**Our ref:** AN/2023/135168/04-L01  
**Your ref:** H16-1096-23  
**Date:** 24 June 2024

**Proposed anaerobic digester plant  
Land between A16 and Rangell Gate, Spalding**

The submitted Preliminary Drainage Strategy dated 21 April 2024, ref: '0371-REP-3000 Rev 00' and Proposed Drainage Strategy ref: '0371-JCE-00-SI-DR-C-3000', prepared by Jackson Consulting Engineers do not satisfactorily address our earlier concerns.

Figure 10 - Foul Connection into Matmore Gate

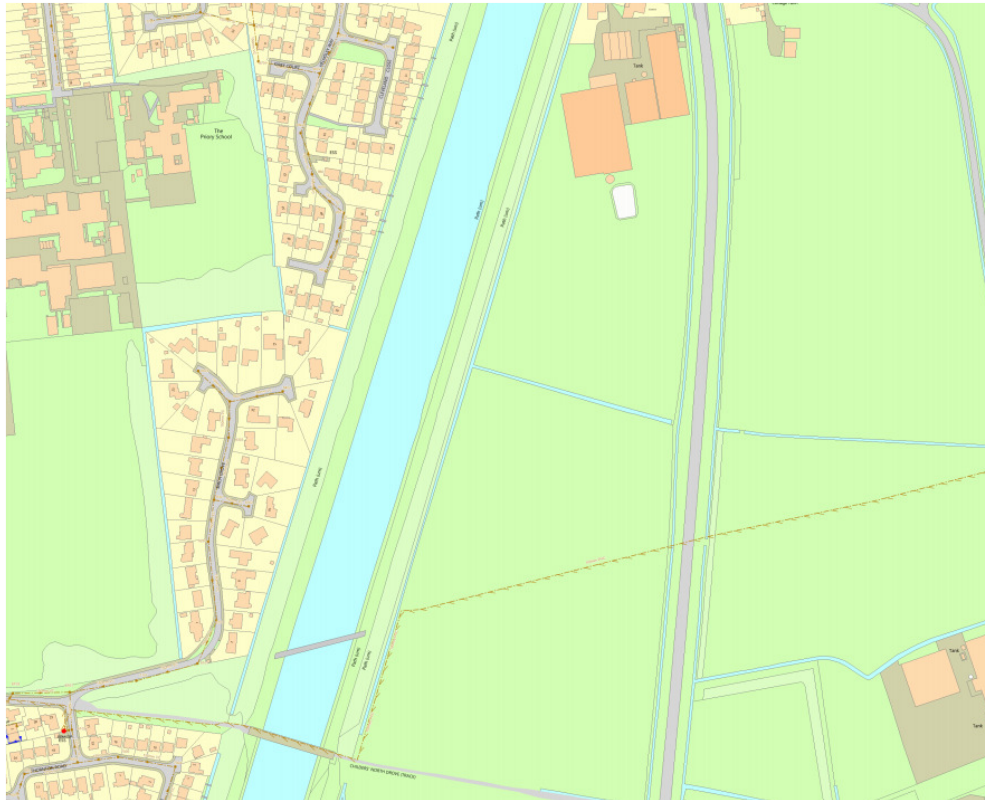
The Preliminary Drainage Strategy states that the length of connection to the rising mains sewer situated to the south of the site would be approximately 0.70km. However, the rising mains sewer network line lies within 15 metres of the sites red line boundary. In addition, the Strategy has stated that the connection is not reasonable in terms of cost; however, no evidence has been provided to support this.

Therefore, following review of the submitted information, we do not consider that the provision of non-mains foul sewage disposal is adequately justified. Further information is required on the cost and/or practicability to assess whether the mains connection for foul sewage disposal is unfeasible.

To overcome our objection the applicant should address the points highlighted above and either revise their application to propose a mains connection or submit evidence that demonstrates that this is not feasible.
